CITY OF ALBUQUERQUE

Re: De Anza
4301 Central Ave. NE
Traffic Circulation Layout
Engineer's/Architect's Stamp **12-25-17** (K17-D106)

Subject: De Anza TCL - K17D106

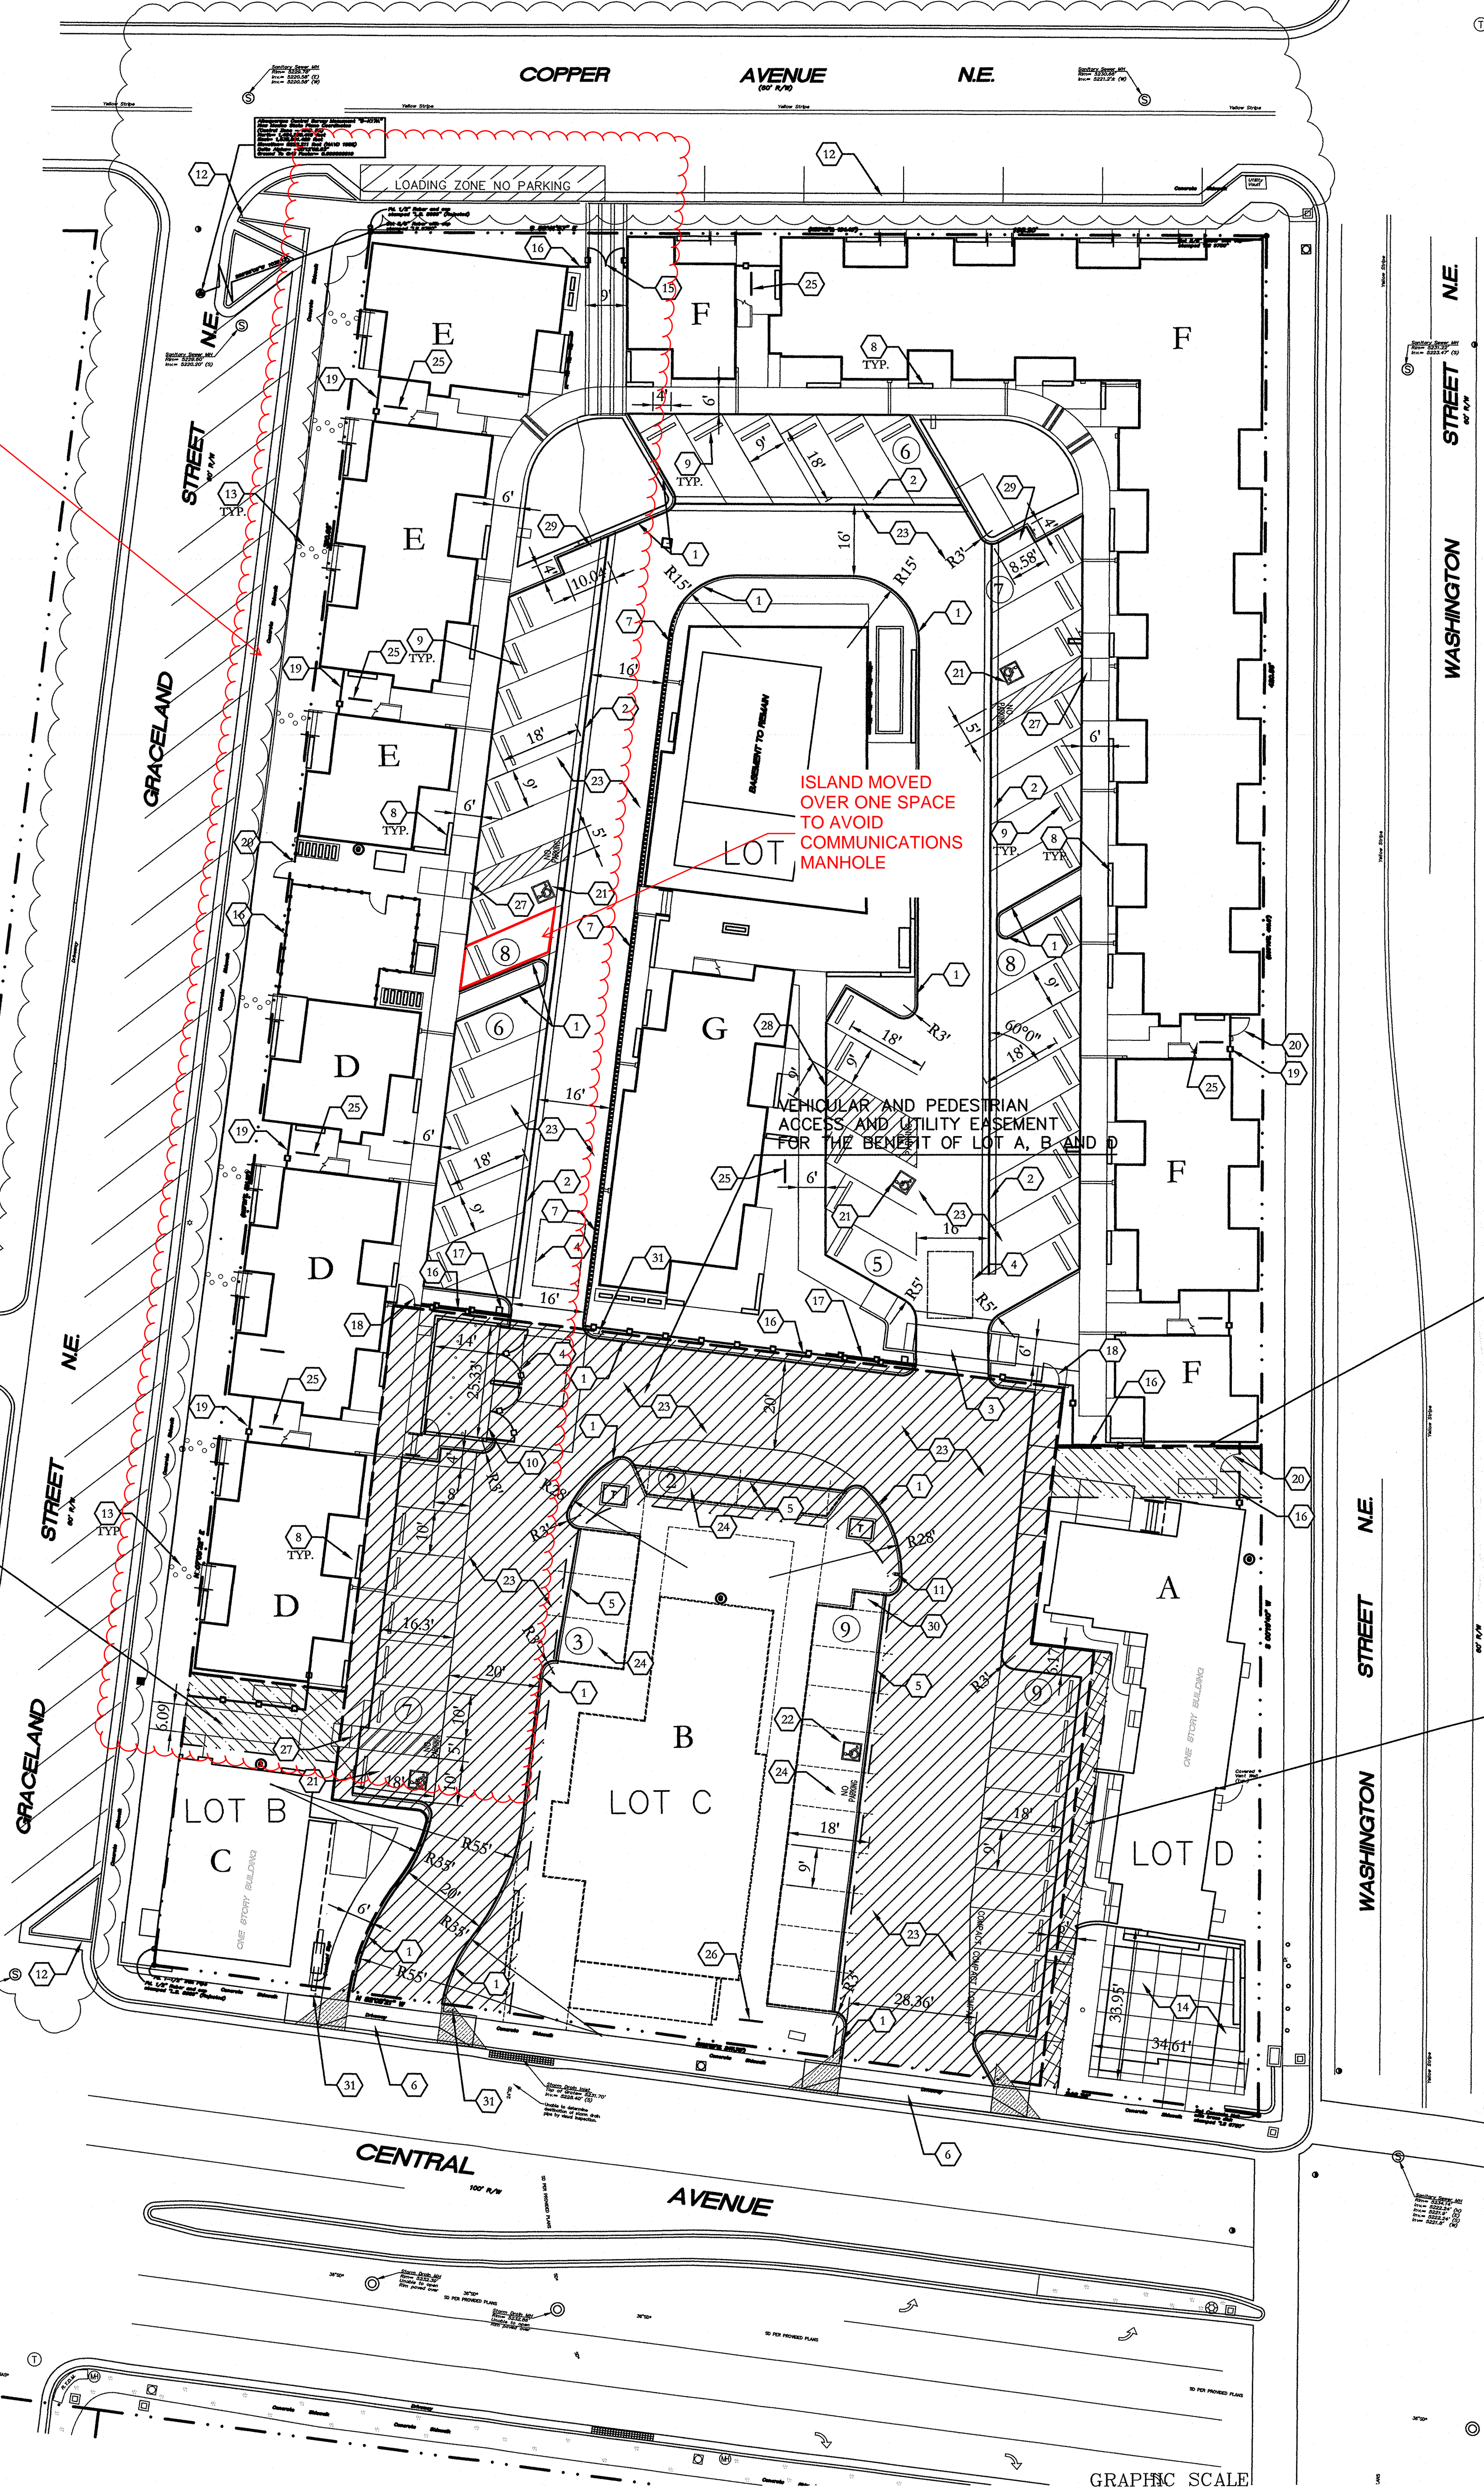
1. The ADA ramp shown in the plans was prior to the ART project coming through and rebuilding the ADA ramps. This is already taken care of under that project.

2. The MC spaces have been distributed around the site to best serve the residents. There are two located on the north end of the motor court near. The other remaining MC space will be constructed under the future office/restaurant building located along Central at the middle of the site. Keyed notes will be added to identify those locations and signage requirements.

3. The "Do Not Enter" signs will be added at the western driveway onto Central as well as the exit gate for the motor court.
4. Note have been added to the sheet. The first phase will be to remodel the Historic Hotel located in the SE corner of the site, and to convert the Turquoise Café into Office space in the SW corner of the site. The second phase will be to construct the residential portions of the site on the northern 2/3 of the site. The last phase will be to construct a future office/restaurant (not know at this point) along Central Avenue in the middle of the site.

5. The COA Project Number is 9043.15 and has been edited onto the notes.
6. Two copies will be delivered in the middle of next week.
